27 May 2014

**Article 21 of the Town and Country Planning (General Development Procedure) Order 1995**  
**Application for approval of details reserved by Condition 19 (watercourse) following a grant of**  
**planning permission R/59/12/.**  
**Sainsburys Supermarkets Ltd, Unit C New Road, Rustington,**

**Condition Number 19**

CCTV Survey

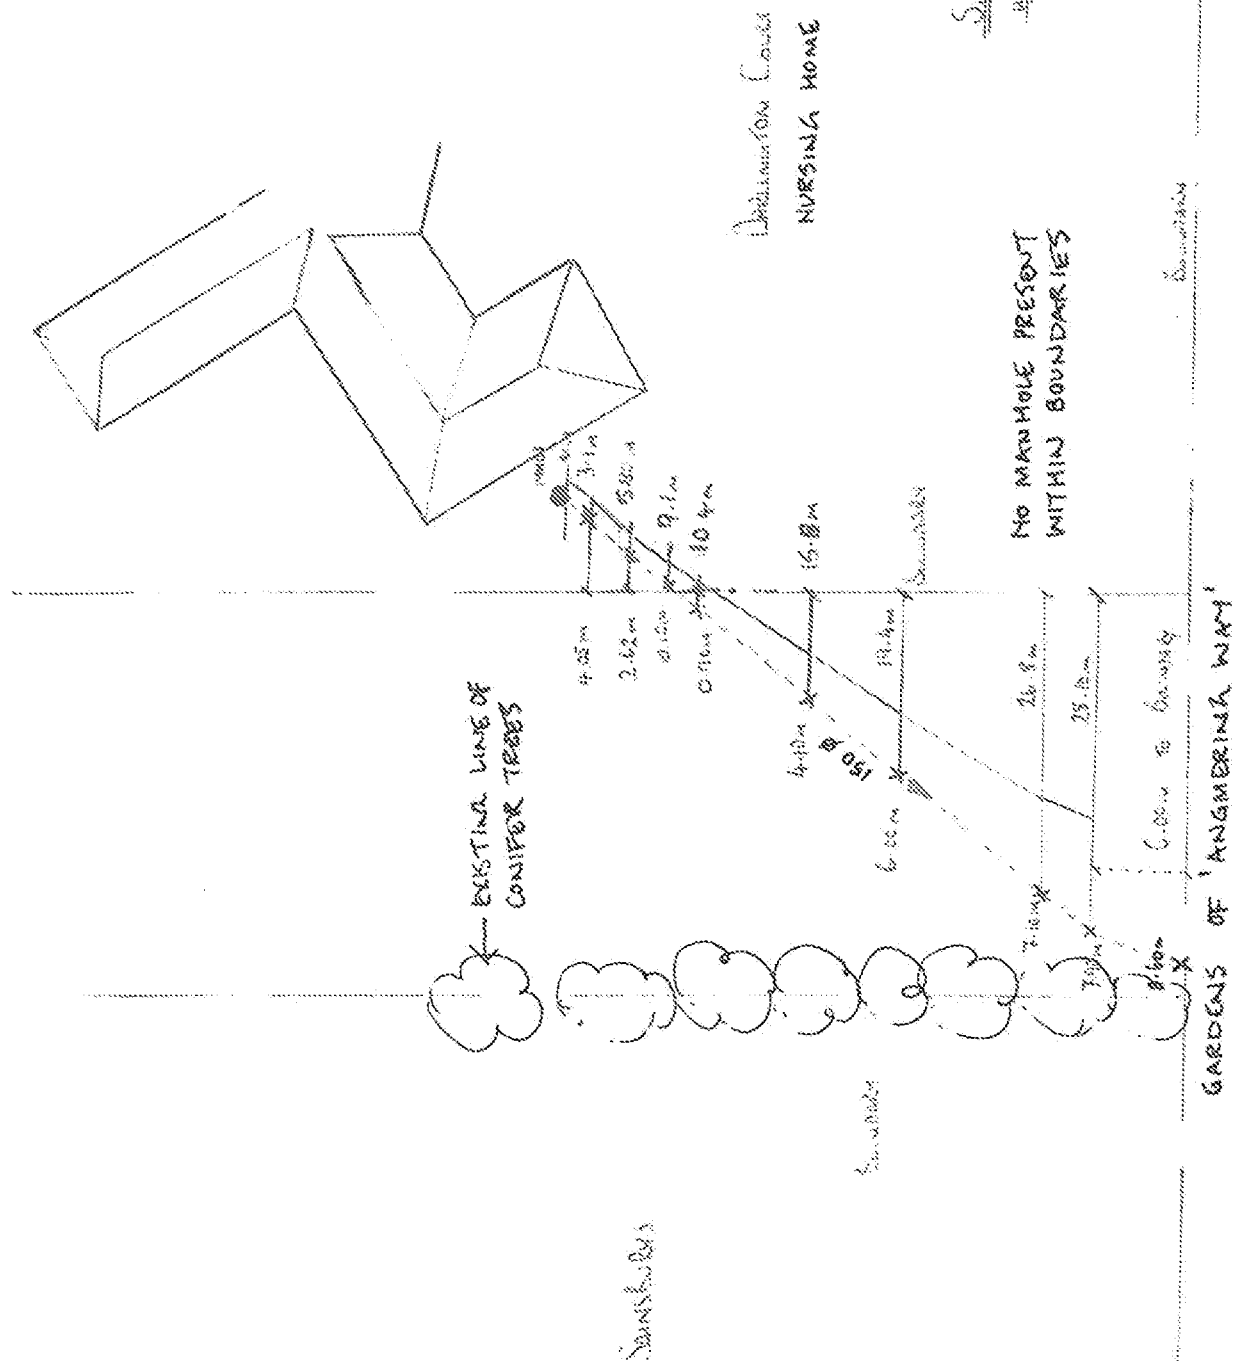
In the course of this site visit the Council's Engineer was able to successfully identify a manhole that was not included in the evidence provided to discharge the condition.

It is therefore considered that the condition should not be discharged and that revised surveys and drawings should be submitted to the Council to discharge the condition.
